Sertil A. Kanbar, PhD, PE, CFM
 City of Albuquerque Planning Department
 Sr. Engineer, Planning Dept. Development Review Services
RE: P10D004A_TCL_BP_Commt

COMMENT RESPONSE LETTER: TCL Plan Review

C2-00

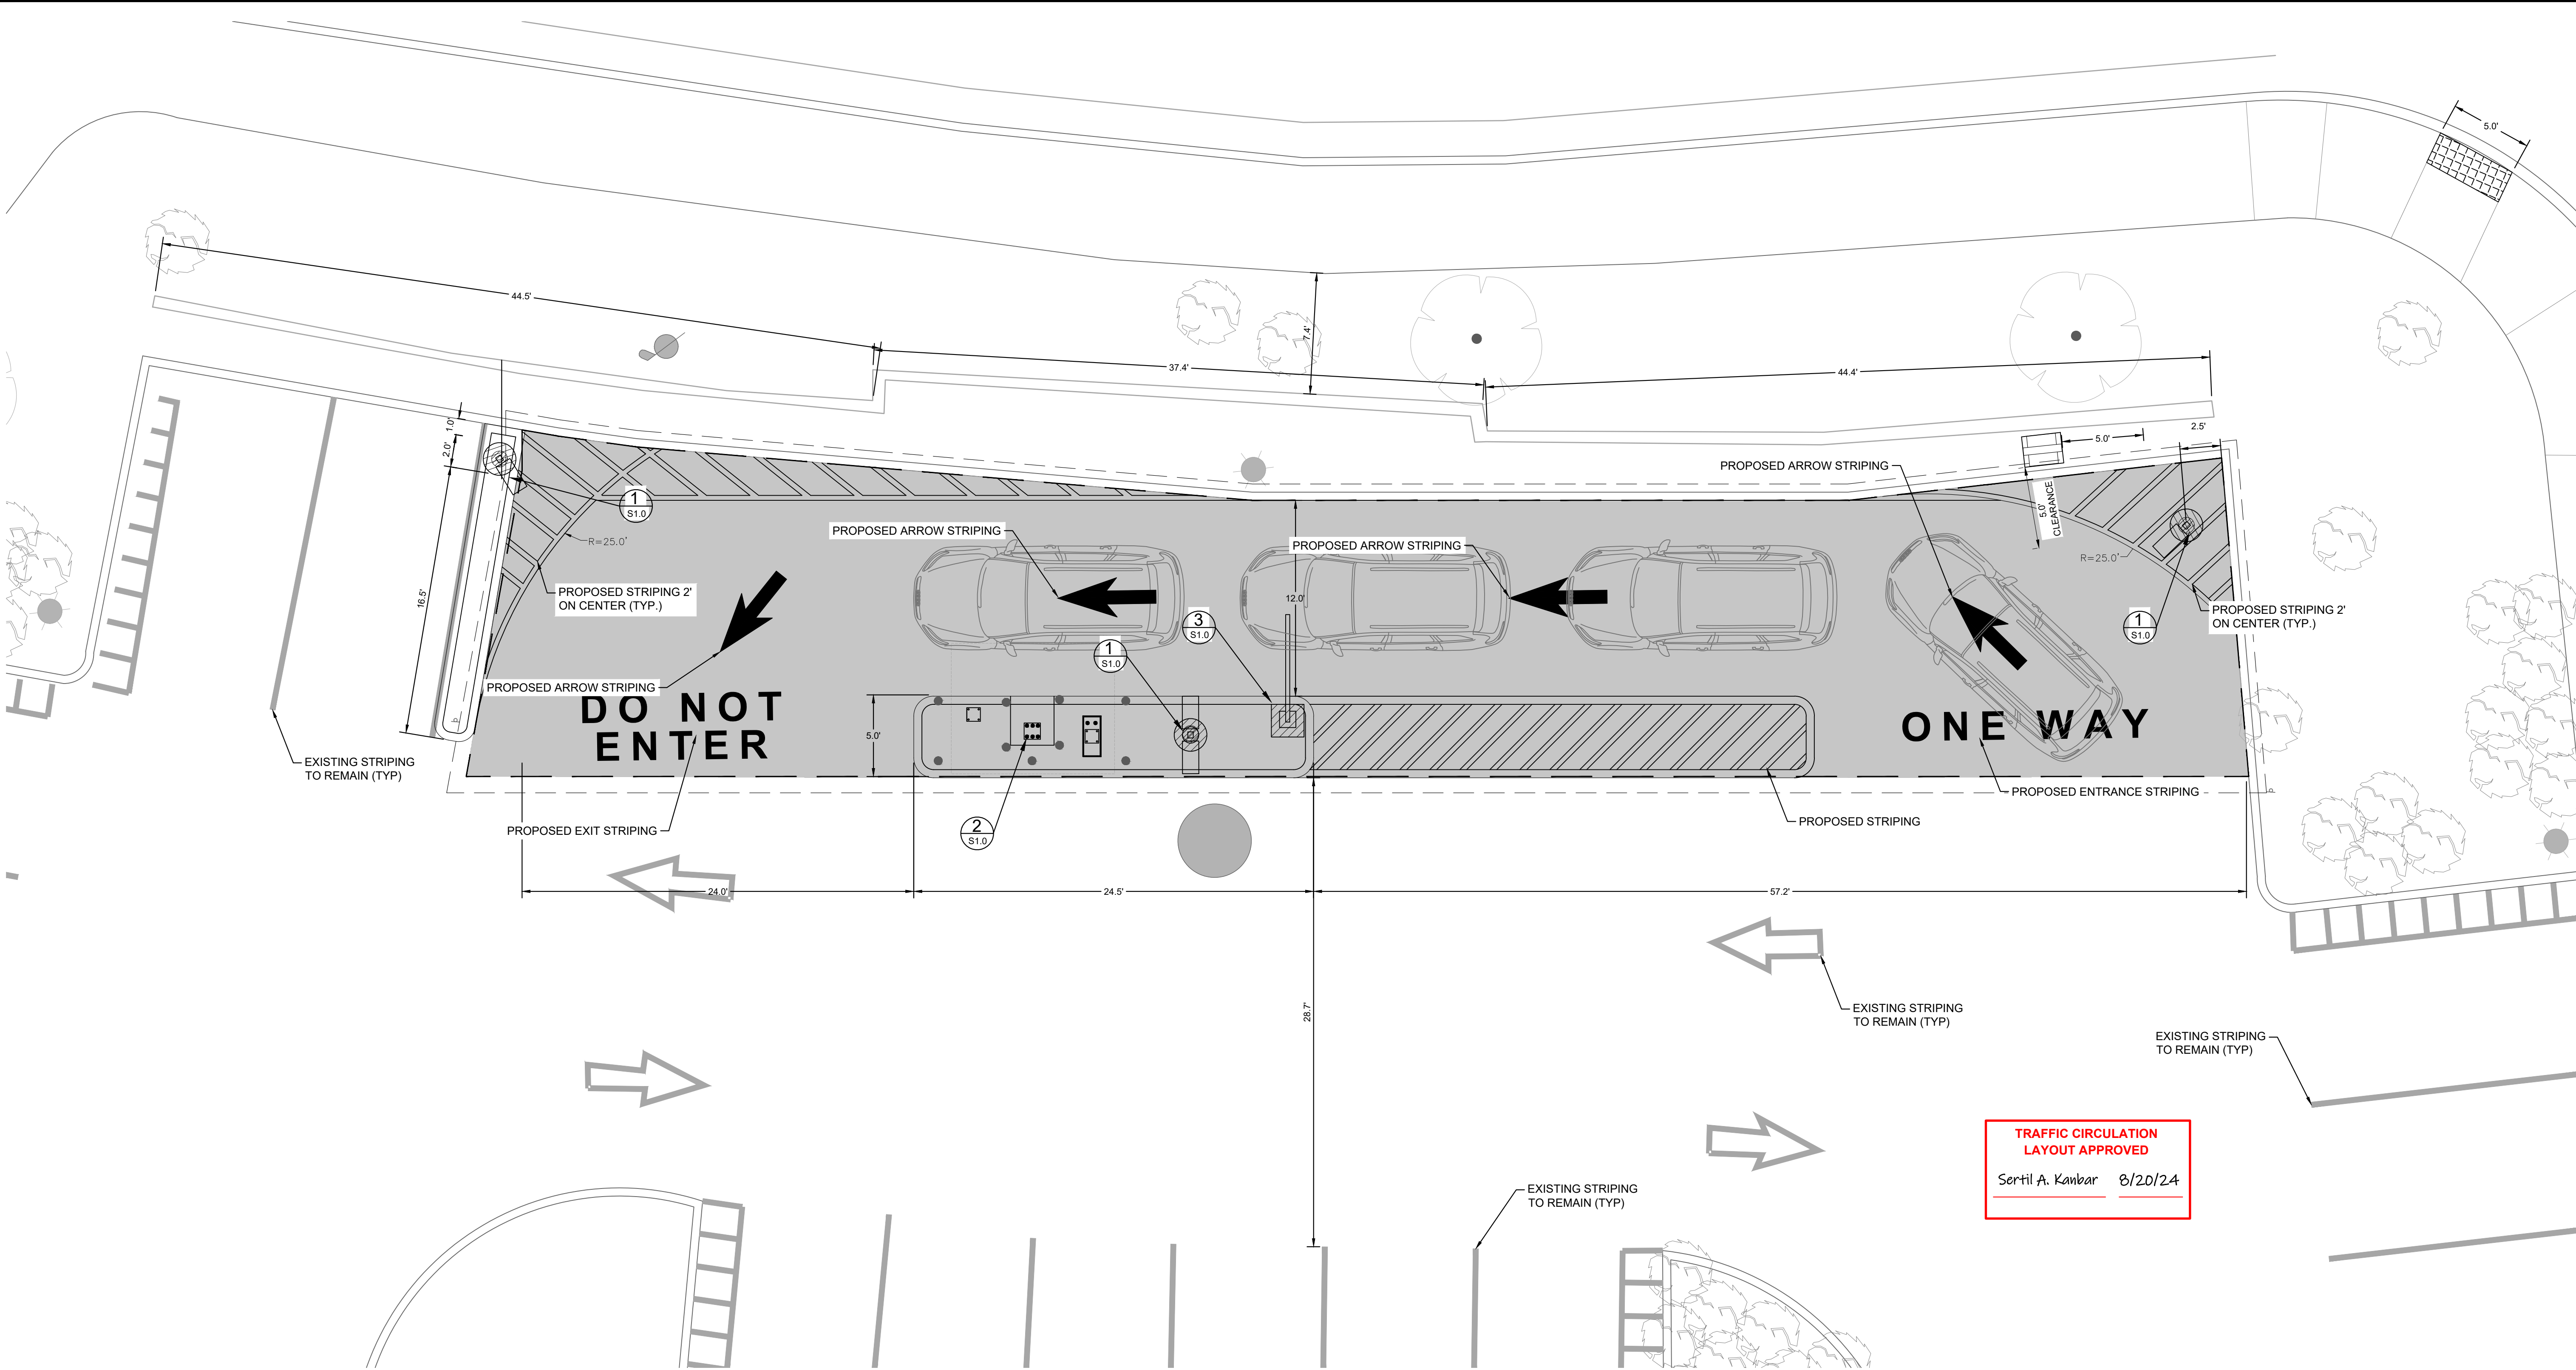
1. The traffic circulation layout must be stamped, signed, and dated by an engineer or architect licensed in the state of New Mexico.
 - **TCL has been stamped, signed, and dated by a licensed engineering in New Mexico.**
2. All one-way drives shall have "One Way" and "Do Not Enter" signage and pavement markings. Please show detail and location of posted signs and striping.
 - **Additional signage and pavement markings added as requested.**
3. The minimum drive through lane width is 12 feet with a 25 foot minimum radius (inside edge) for all turns.

- **Understood, the drive lane width has been updated to 12' and the radii have been called out.**
4. Minimum required stacking spaces (of 20 ft each) is 4 spaces measured from end of queuing lane to Teller window/ATM. Add another space and label the dimension of each space in the drive through lane.

- **Comment resolved. See email correspondence from Sertil Kanbar to Maddy Kish (maddy.kish@kimley-horn.com) on 8/2/2024.**
 5. Add a note stating "All broken or cracked sidewalk must be replaced with sidewalk and curb and gutter." A build note must be provided referring to the appropriate City Standard drawing.
